CITY OF ALBUQUERQUE

February 28, 2014

**Re: Gillani Office Building, 10412 Manual NE,
Traffic Circulation Layout
Architect's s Stamp dated 2-27-14 (H21-D049)**

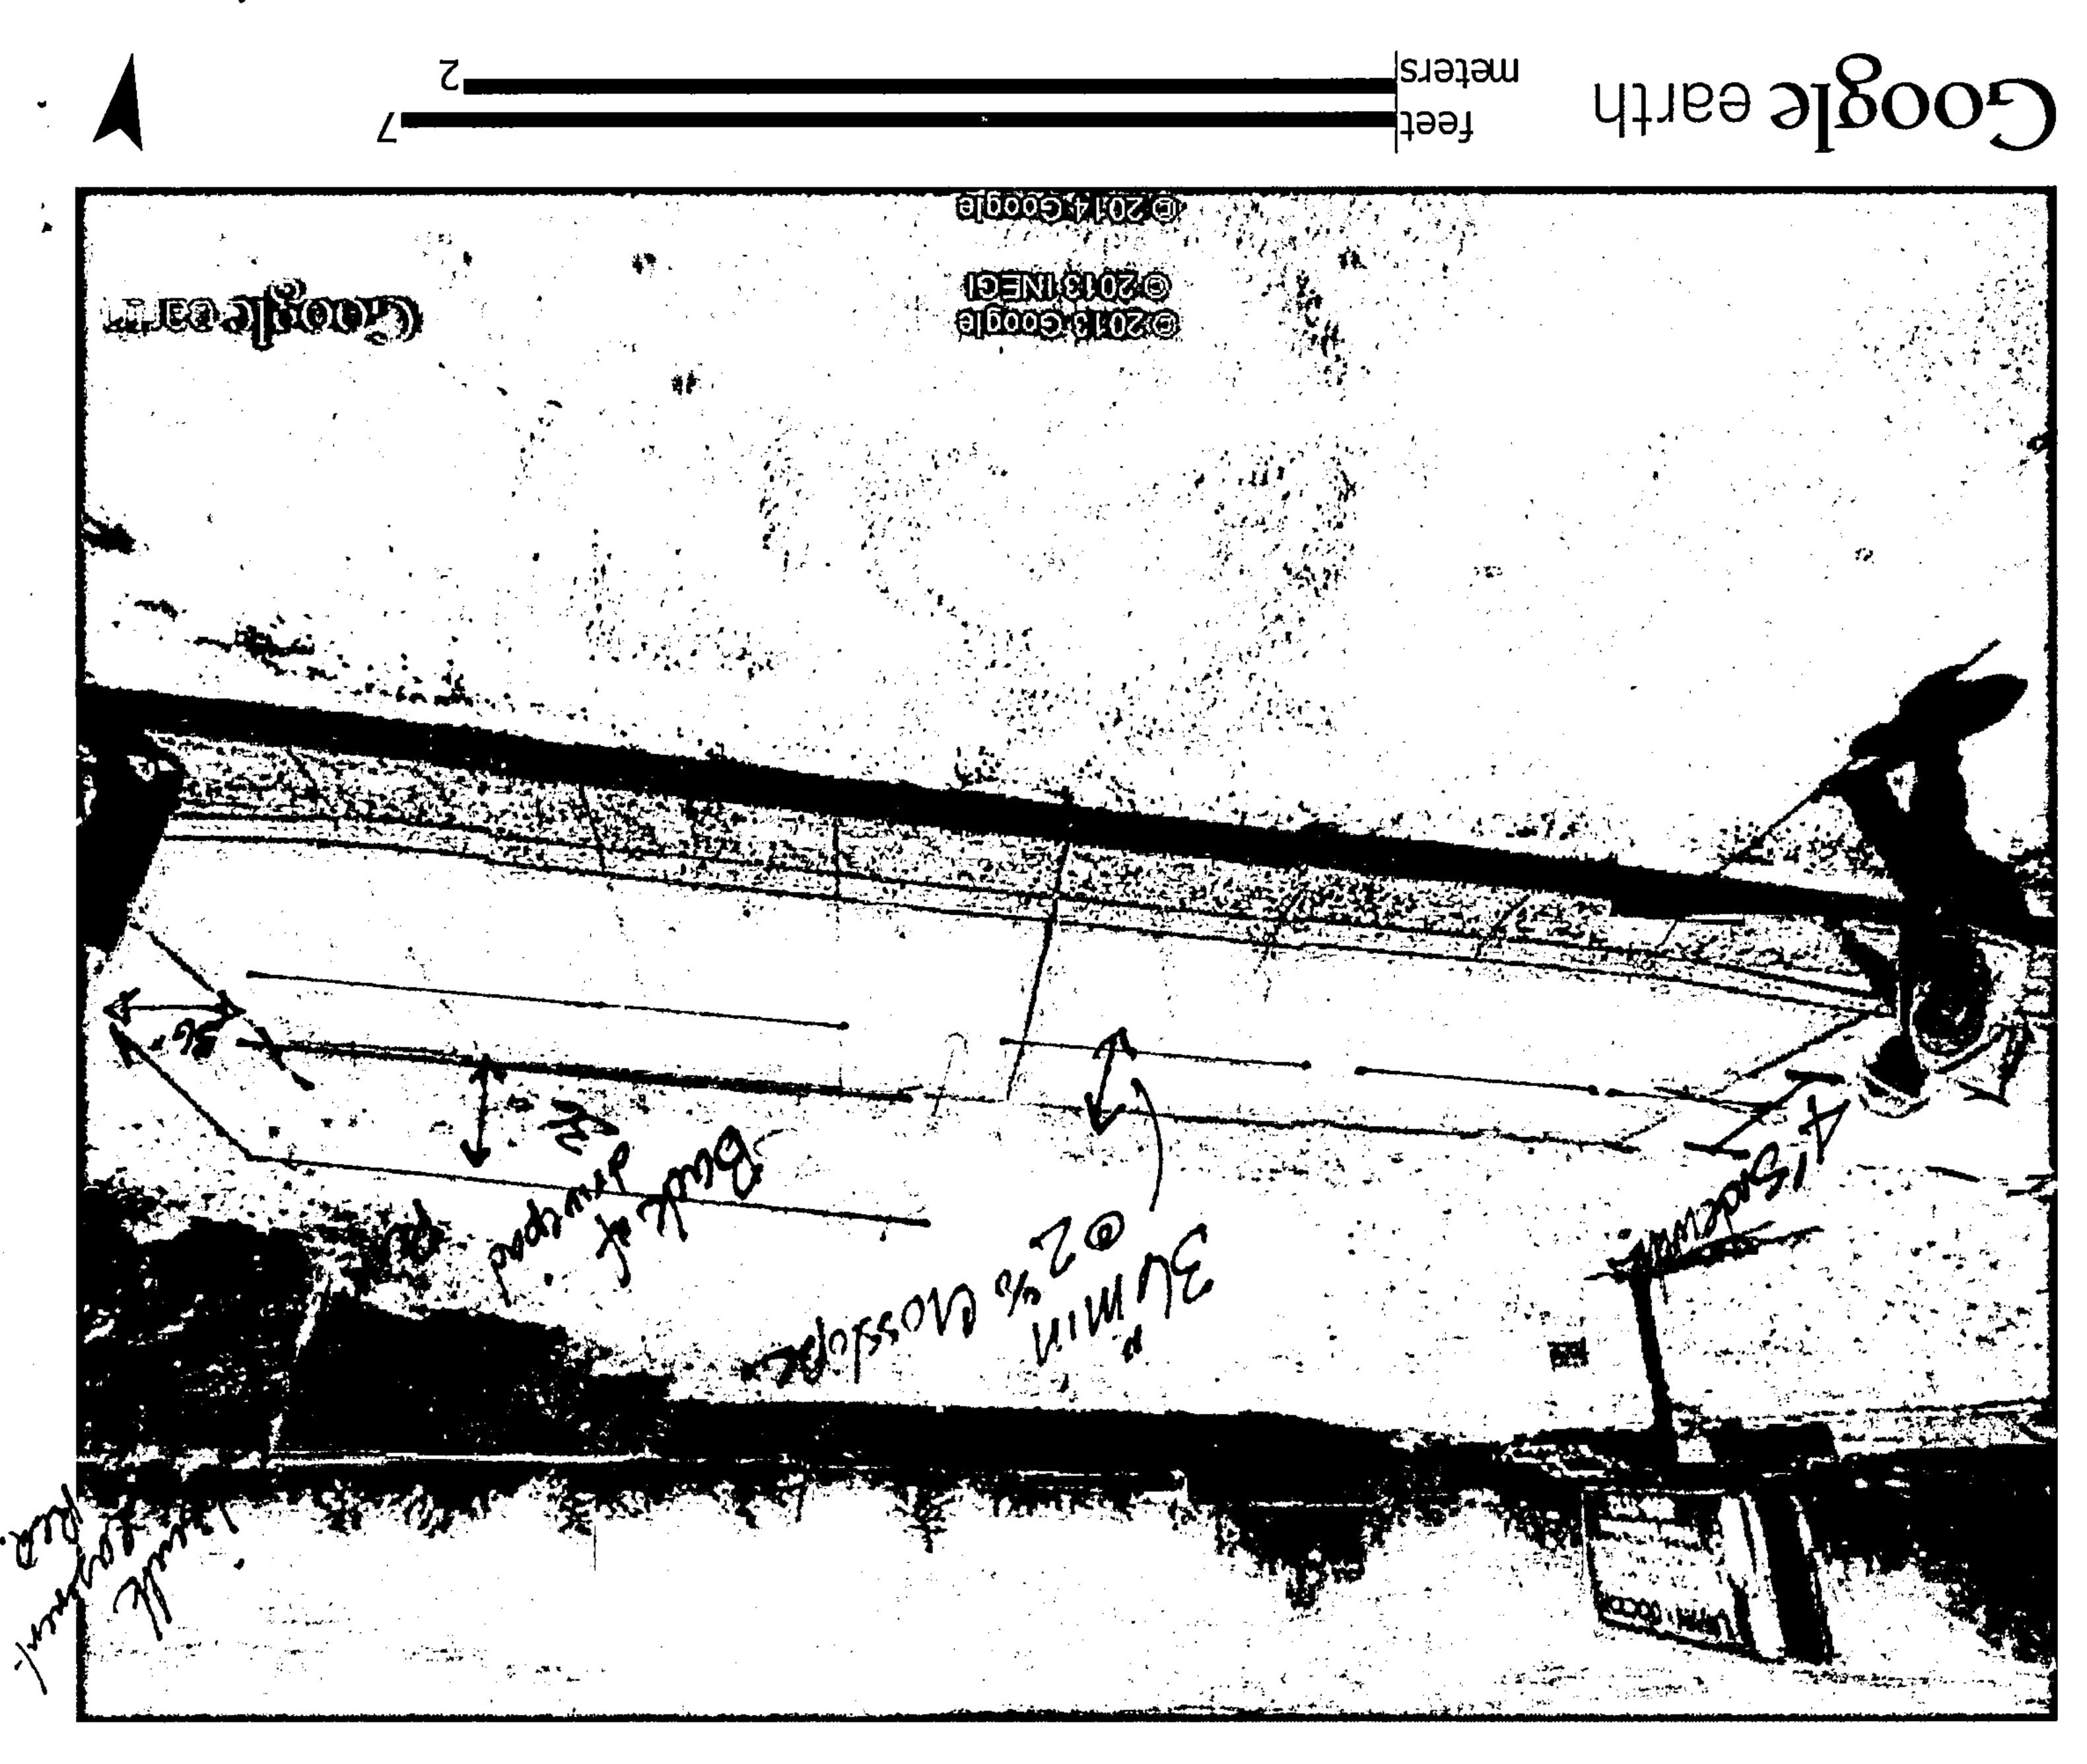
1. Please show a vicinity map that includes primary street names.
2. Please include the address, 10412 Manual NE, on the TCL
3. The development of this site must be in compliance with current DPM and ADA standards and regulations

4. Is the existing drivepad ADA compliant? A minimum 36 inch wide concrete pedestrian crossing must be provided, no greater than 2% cross slope. Please show compliance or provide a solution to meet this requirement. If a proposal provides a sidewalk connection within the property, a Permanent Sidewalk Easement must be provided.

5. Please list the width and length for all parking spaces.
6. Label the compact parking spaces by placing the words "compact" on the pavement of each space.

7. The handicapped spaces must be a minimum of 8.5 feet in width.
8. The handicapped space must include a minimum 8-foot wide van access aisle.
9. The handicapped parking spaces and access aisle require ADA compliant pavement markings and posted signage. Please reference attachment provided for the Revised 2009 ADA parking requirements with revisions as of July 2013.

10. The handicapped spaces require wheelstops set 2 ft from curb ramp to prevent vehicle overhang encroachment.
11. Per the DPM, a 6 ft. wide ADA accessible pedestrian pathway is required from the public sidewalk to the building entrances. A 6 ft pathway is shown but ADA accessibility is unclear. Please provide details.

12. Please ensure all ramps are ADA compliant.
13. It is not apparent what type of pavement surface is being proposed for the Dumpster Enclosure. Please clarify.

14. It appears the Dumpster gates swing into adjacent parking spaces.
15. The motorcycle space requires a posted sign per the DPM.
16. Is landscaping required by zoning? If so, please provide landscaping plan with next submittal. Per the *Development Process Manual*, Chapter 23, Section 7, Part B.6, curbing should be used to separate landscaping from parking areas (including adjacent property) and pedestrian ways as well as providing a physical perimeter for harvesting water. This must be clearly shown on the TCL.

17. Please add the following note: "Landscaping and signing will not interfere with clear sight requirements. Therefore, signs, walls, trees, and shrubbery between 3 and 8 feet tall (as measured from the gutter pan) will not be acceptable in this area."

18. Will this site be developed in phases? Is there intent to develop the southwestern area of the lot?
